CITY OF MERCER ISLAND

Pre-Application Meeting (PRE24-028)

Site Location:	4327 Forest Ave SE	Parcel Number	9365700344
Lot Size:	14,455 SF	Zoning:	R-15 (Single Family)
Brief Project Description:	Install one new boatlift, one new dock mounted PWC lift, and remove 1 mooring pile.	Documents Provided:	<ul style="list-style-type: none">• Pre-application request form.• Preliminary plans.• Questions for reviewers.• Project narrative.• SEPA checklist
Applicant Information:			
Name: Zion Napier		Email: permits@sebornpiledriving.com	Phone: 206-236-1700
Second Pre-application Meeting Required:	Not Applicable	Click for explanation if necessary

SITE PLAN

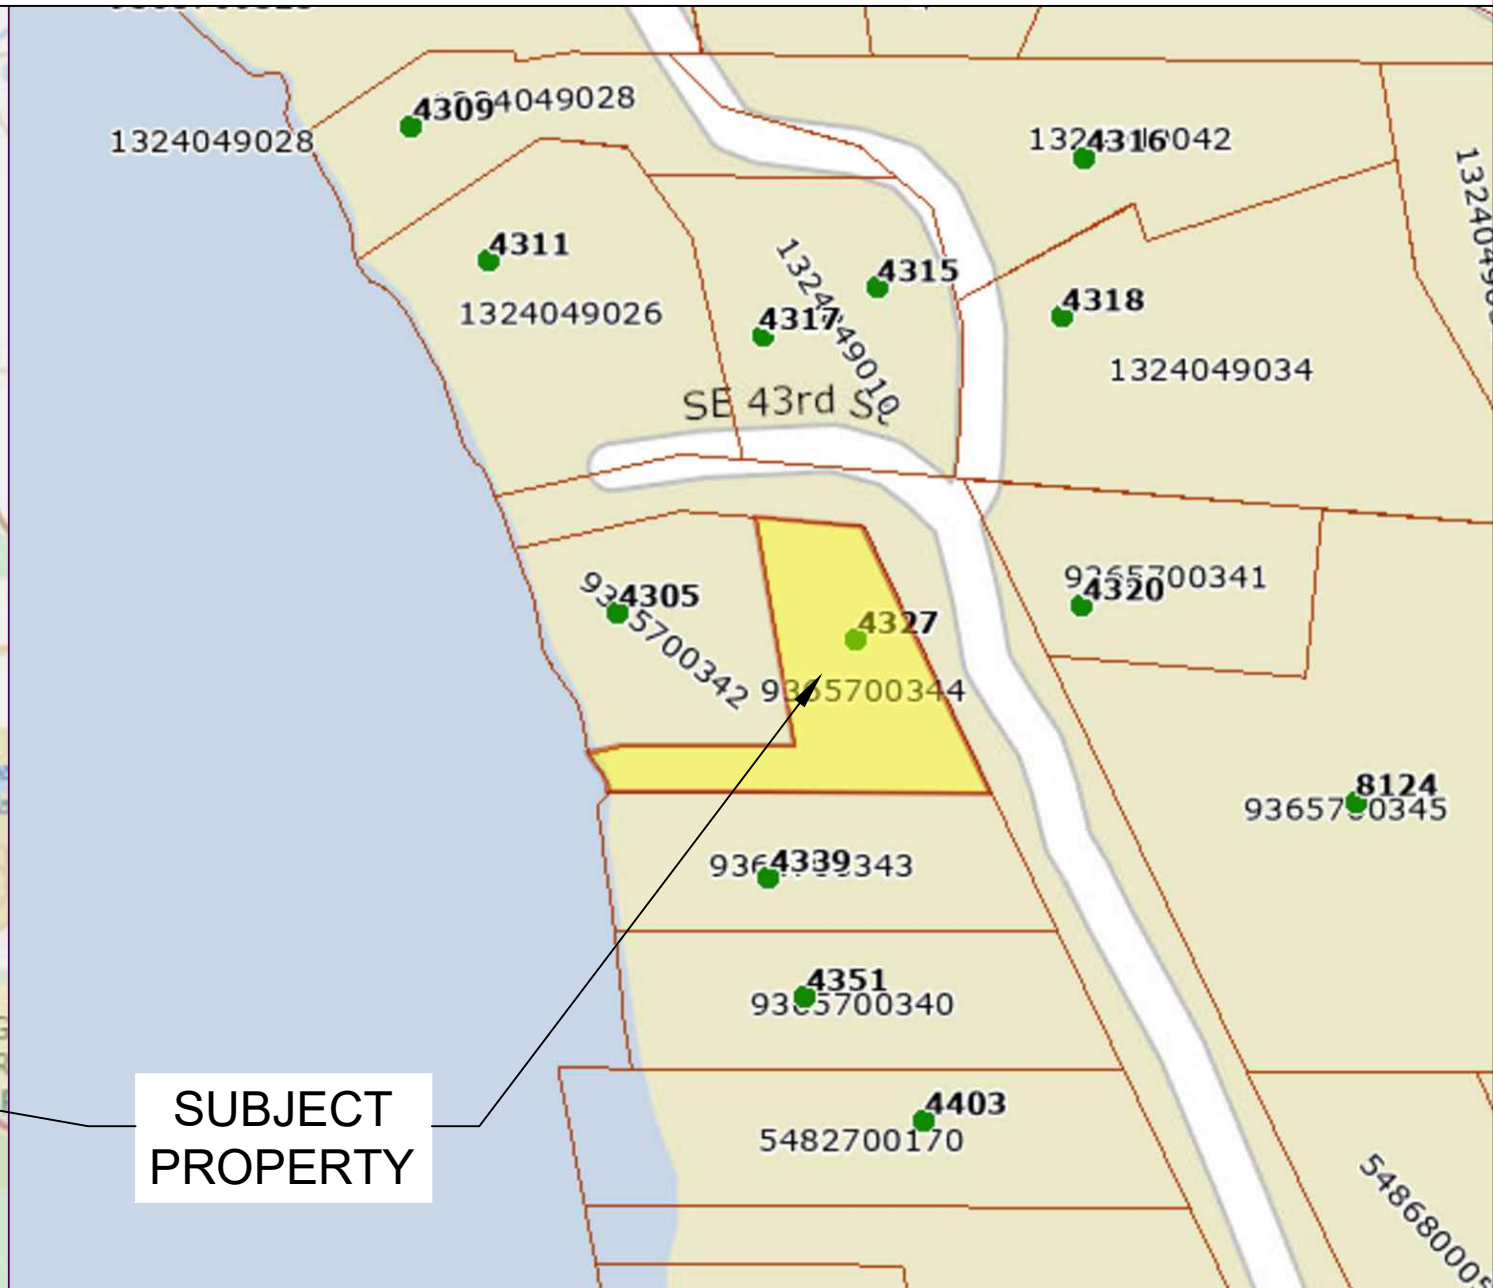
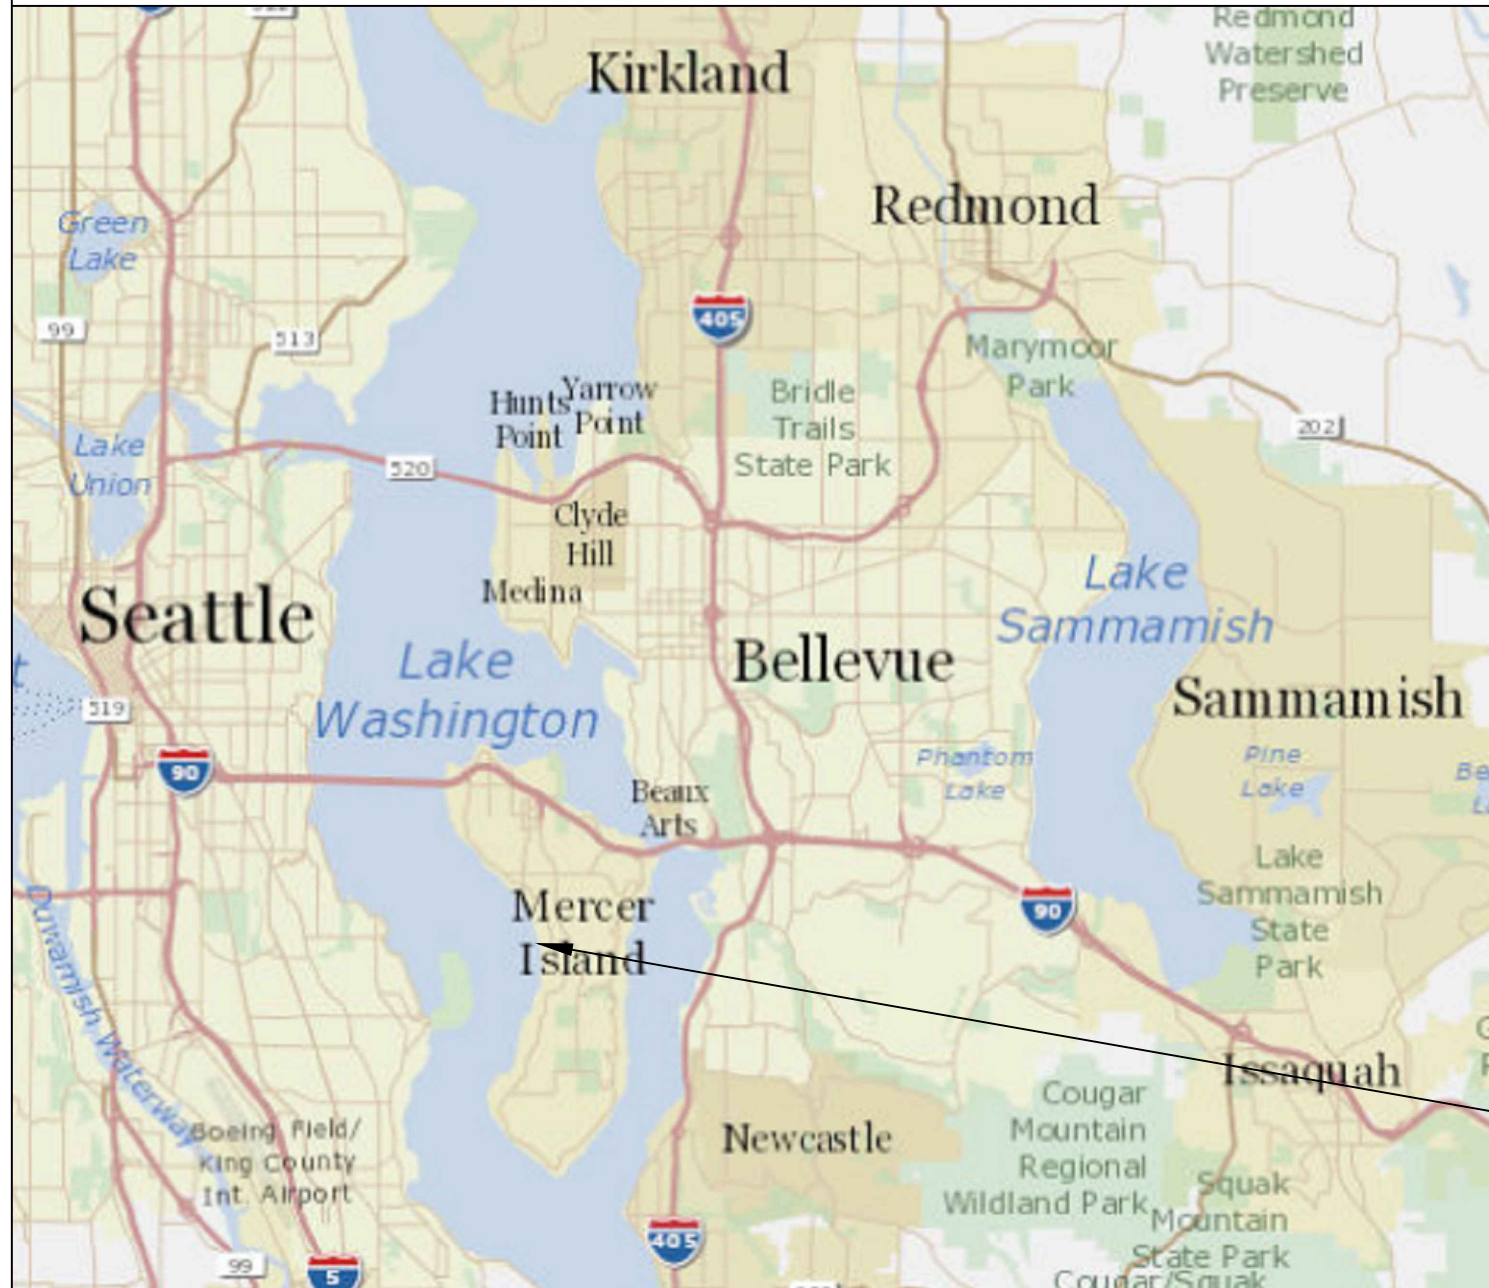
2. The provided establishment permit drawing shows the lateral line extending from the northern portion of the parcel. Will this line be upheld in during land use review?

Staff Response: The applicant may submit whatever they feel meets the city's requirements. Additional information may be requested once the official review has begun.
